**KIRKLEES METROPOLITAN COUNCIL
INVESTMENT & REGENERATION SERVICE**

**DELEGATED DECISION FOR APPLICATION FOR CERTIFICATE OF
LAWFUL DEVELOPMENT**

Reference no.: 2026/CL/90836/W

Site: 59, Raw Nook Road, Salendine Nook,
Huddersfield, HD3 3UX

title  
Plans & Elevations - As Proposed

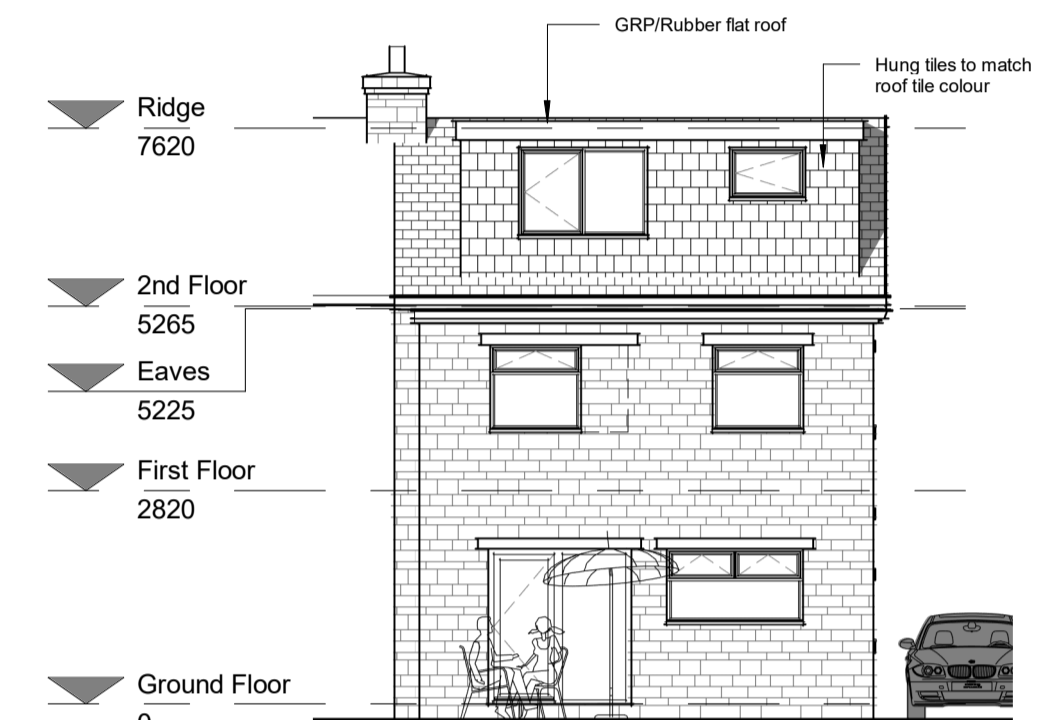
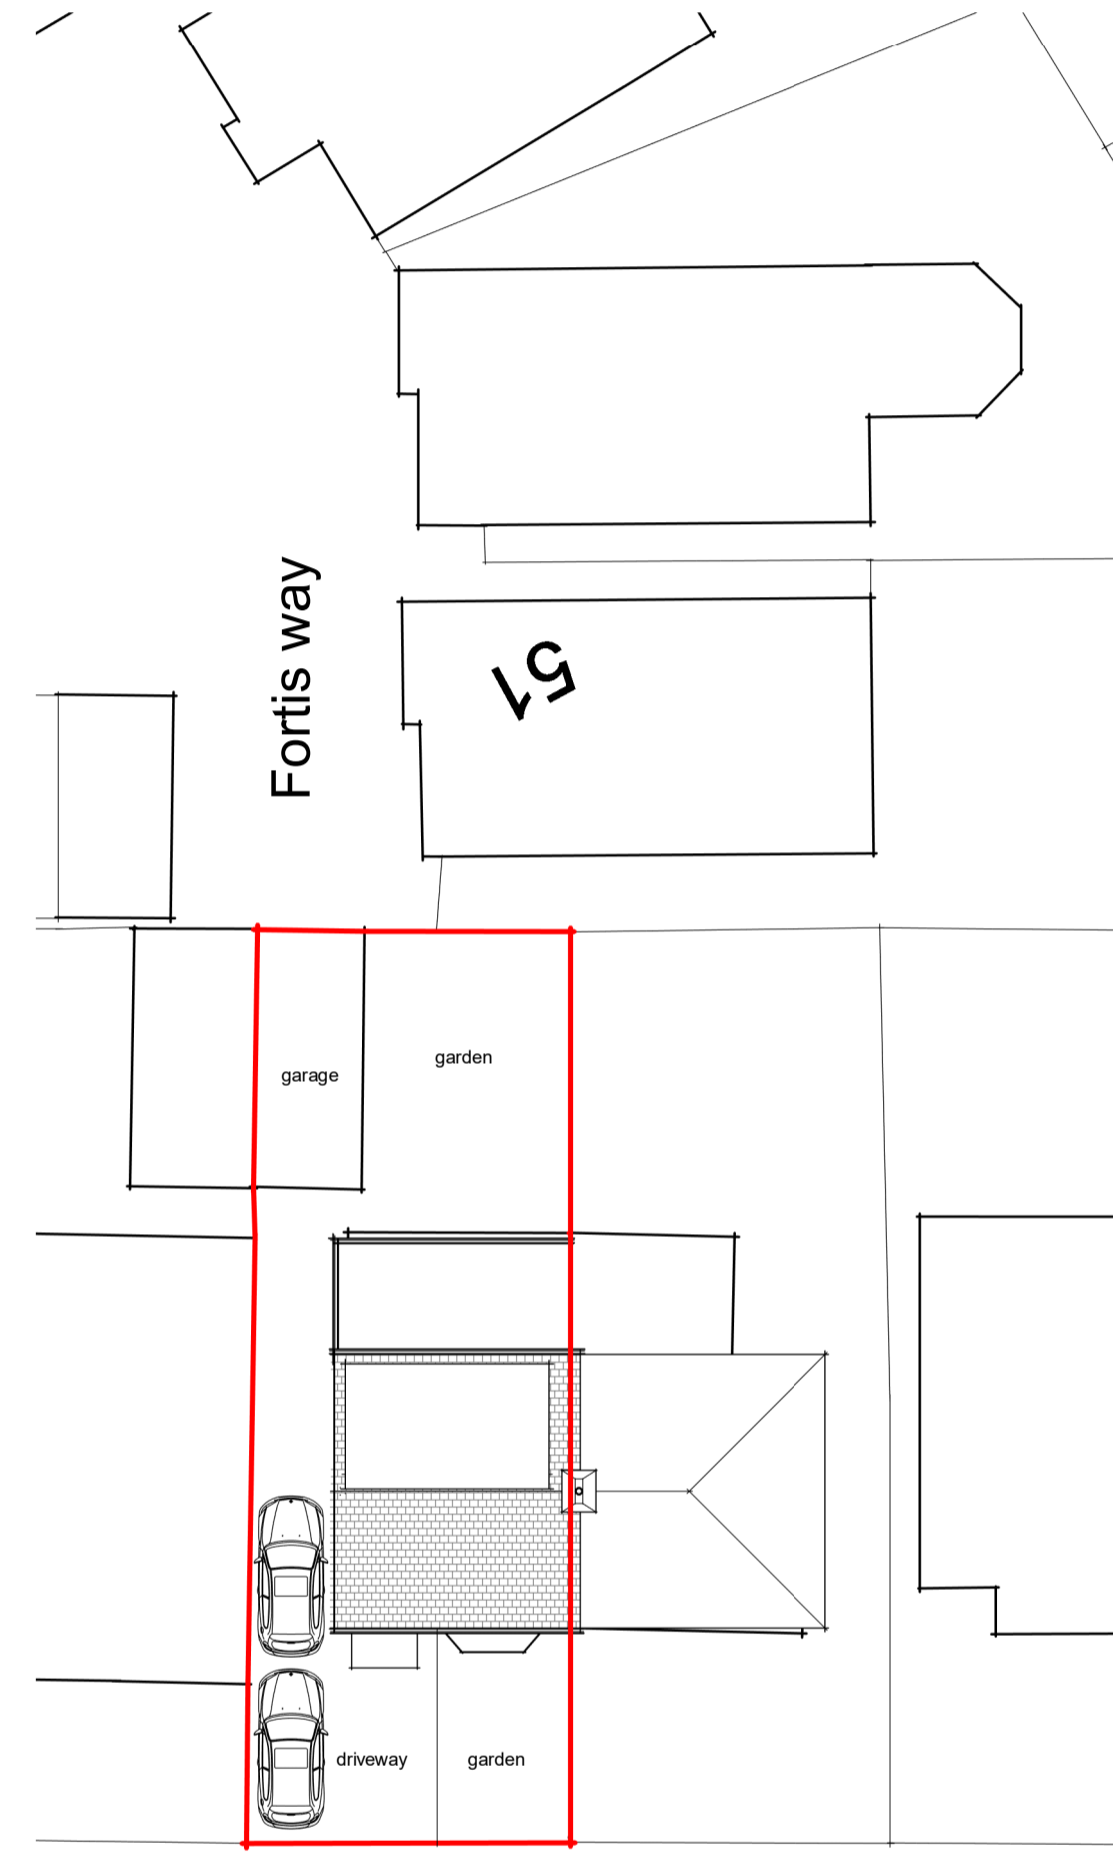
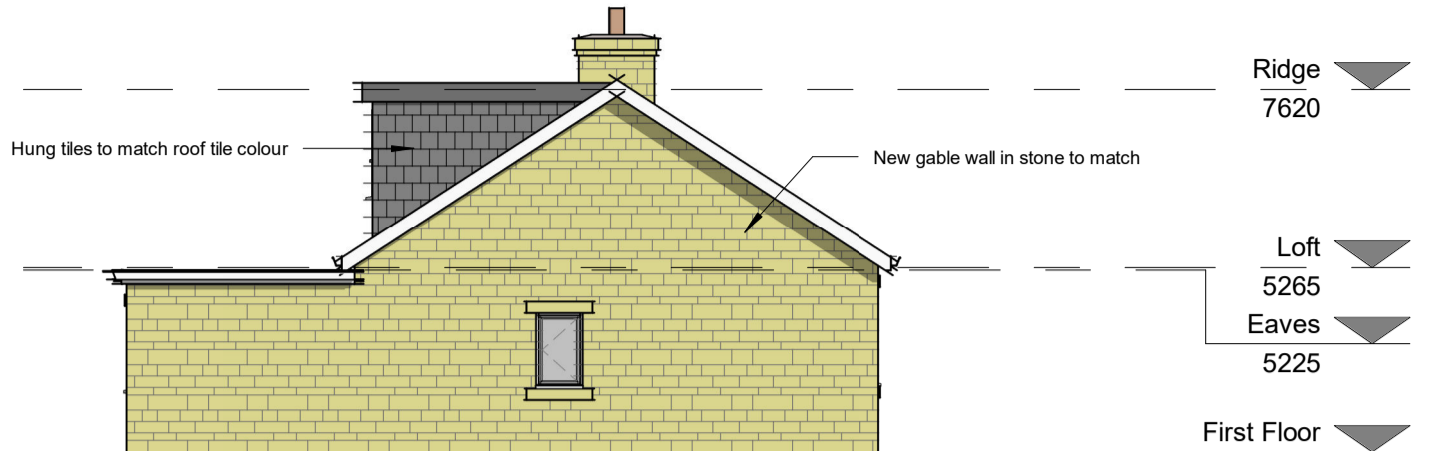
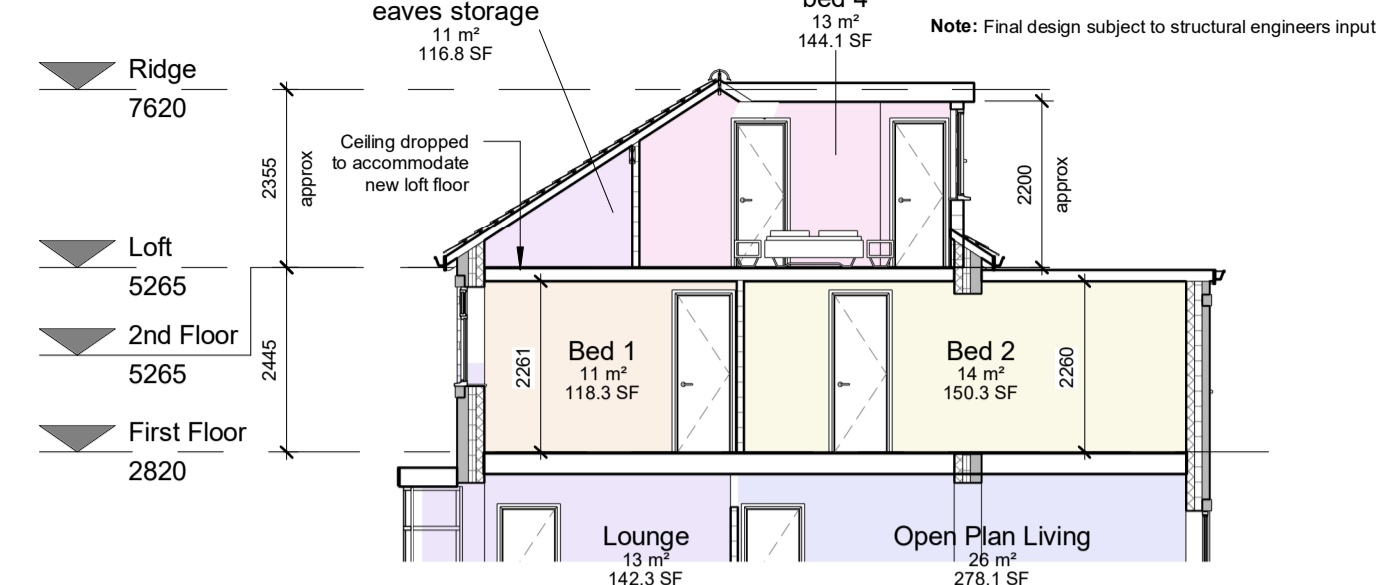
The application is for a certificate of proposed lawful development for the erection of a rear elevation dormer extension. The plans also demonstrate that a hip to gable roof enlargement is also proposed.

The hip to gable roof form would have the following resultant roof space:

Total resultant roof space – $3.6 \times 7.3 \times 2.4 / 6 = 10.5$ cubic metres

The dormer would have the following dimensions:

Total resultant roof space – $5.2 \times 2.7 \times 1.9 / 2 = 13.4$ cubic metres

Comment: *No part of the works would exceed the height of the highest part of the existing roof.*

Comment: *No part of the works would extend beyond a plane of the existing roof slope which forms the principal elevation of the dwellinghouse and fronts a highway.*

Comment: *As a semi-detached property, the maximum additional roof volume permitted is 50 cubic metres. The proposed additional volume is within this limit.*
